WEST SUSSEX COUNTY COUNCIL CONSULTATION

TO:	Arun District Council FAO: Harry Chalk
FROM:	WSCC – Highways Authority
DATE:	6 November 2025
LOCATION:	44A & 44 Pagham Road Bognor Regis PO21 4NP
SUBJECT:	P/118/25/PL 1 No 4 bed chalet bungalow and extension to existing dwelling. This application is in CIL Zone 4 and is CIL Liable as a new dwelling.
DATE OF SITE VISIT:	n/a
RECOMMENDATION:	Advice

This application is for the erection of one 4-bed chalet bungalow and alterations / extensions to existing bungalow. The site is located on Pagham Road, a C-classified road subject to a speed limit of 30mph.

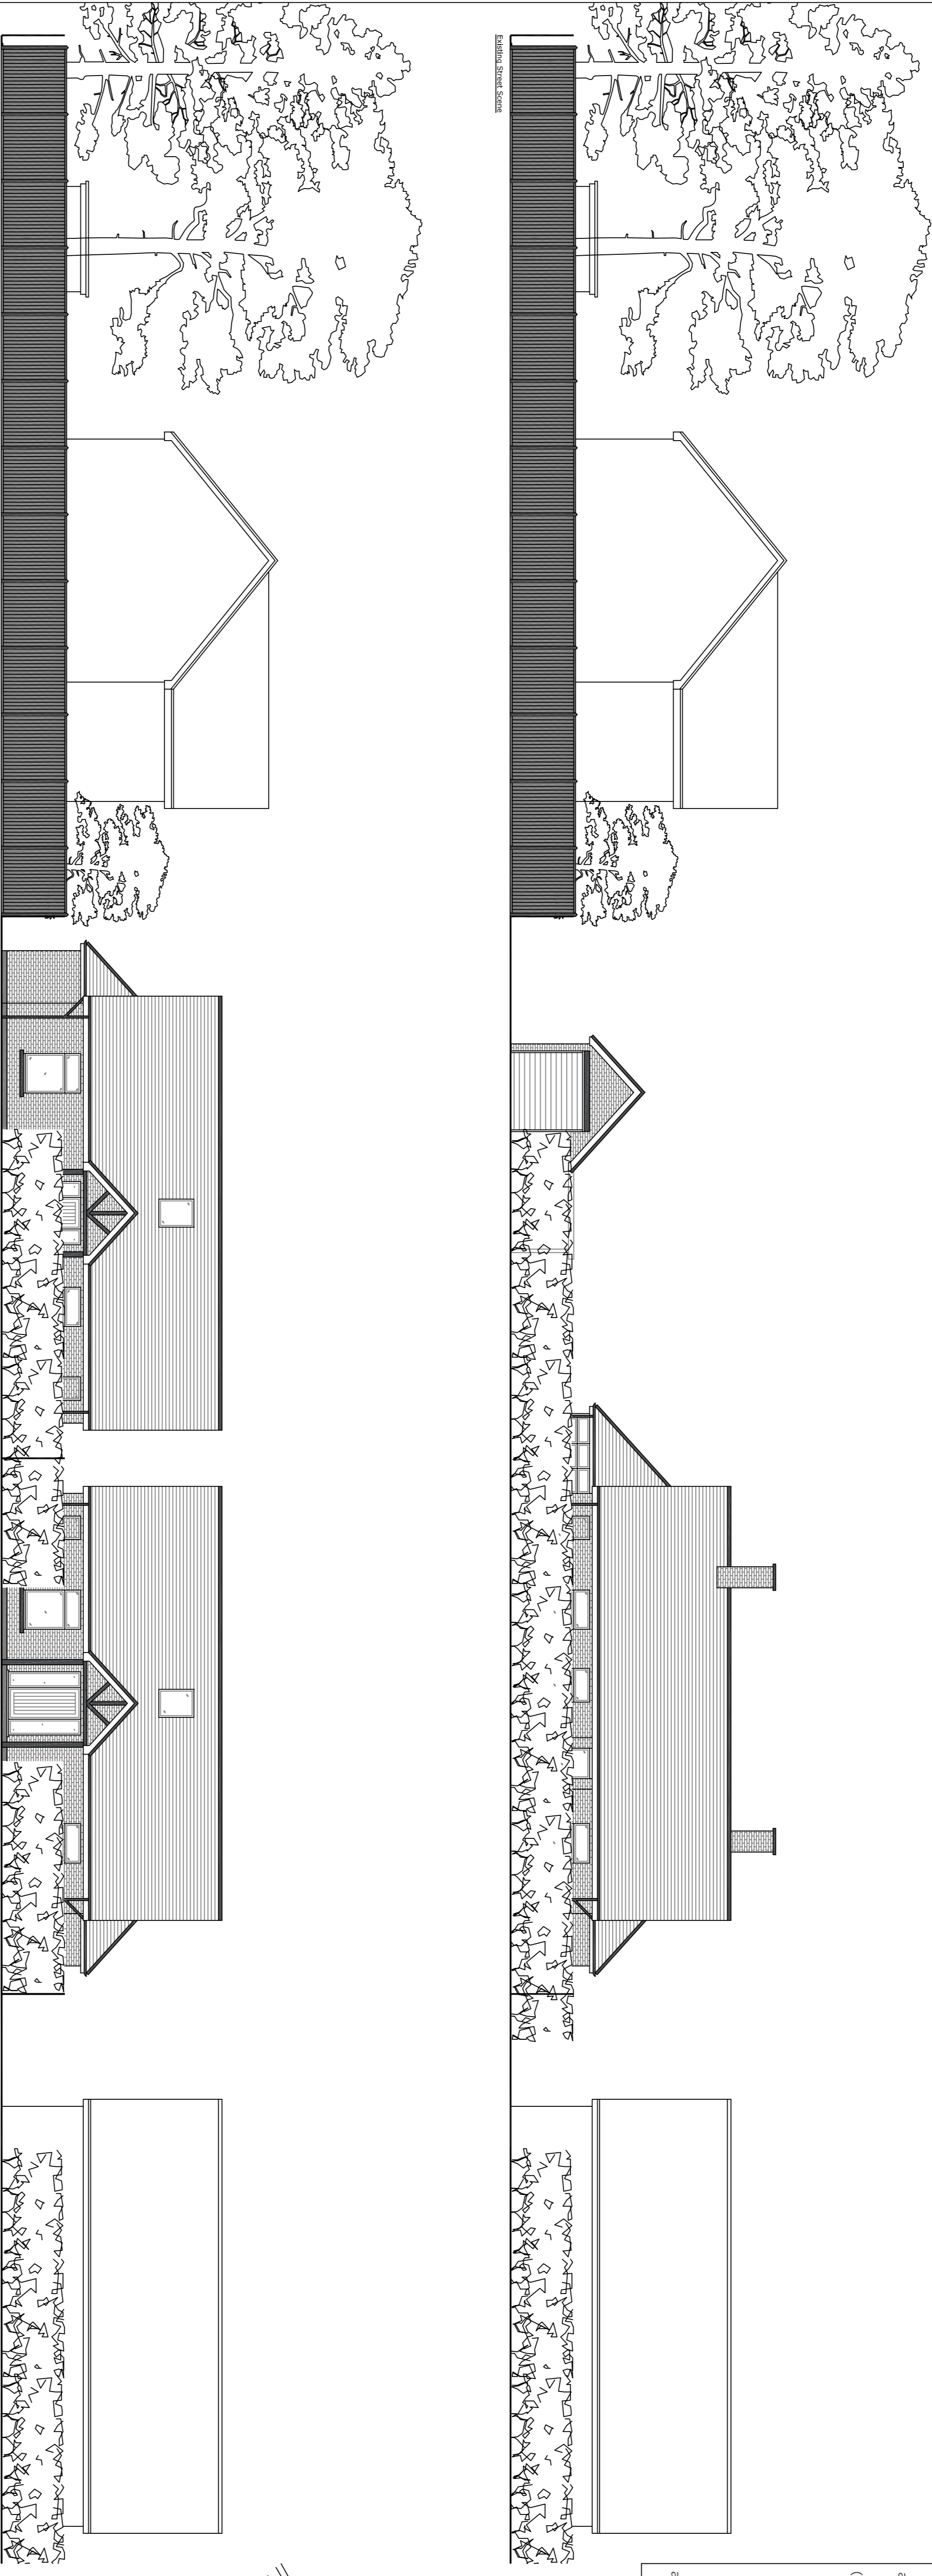
The proposed plans do not clearly demonstrate existing and proposed access arrangements. It is assumed that the new dwelling will utilise the existing access serving the host dwelling and a new access will be constructed to provide parking for the existing dwelling. Details of access can be secured via condition, and any access works must be constructed under licence, to a specification agreed with the WSCC Area Engineer.

Visibility at the existing access is considered sufficient for the anticipated road speeds and the proposal is not anticipated to result in a material intensification of use of the existing access. Some form of visibility splay has been demonstrated at the proposed access; however, this has not been annotated. The LHA would expect splays of 2.4 x 43m to be provided at the proposed access point, in accordance with Manual for Streets. However, an inspection of WSCC mapping indicates that these splays are achievable and maintainable wholly within the public highway in this location.

The plans indicate that two parking spaces will be provided for each dwelling. The WSCC parking demand calculator would expect that three parking spaces would be required per dwelling in this location. The applicant is encouraged to consider increasing the proposed parking provision. The LHA would not raise any highway safety concern to overspill on-street parking in this location, however the LPA may wish to consider the amenity impacts of additional on-street parking.

The site is located within walking distance of shops and services, including bus stops providing links to Bognor Regis and Chichester. Cycling is a viable option within the vicinity and secure and covered cycle storage should be provided for the proposed dwelling. The LPA may wish to consider whether alternative cycle storage provision is required for the host dwelling, given the loss of the garage building.

No part of the development shall be first occupied until such time as the vehicular access has been constructed in accordance with plans and details to be submitted to and approved in writing by the Local Planning Authority.

No part of the development shall be first occupied until the car parking has been constructed in accordance with the approved site plan. These spaces shall thereafter be retained at all times for their designated purpose.

No part of the development shall be first occupied until covered and secure cycle parking spaces have been provided in accordance with plans and details to be submitted to and approved by the Local Planning Authority.
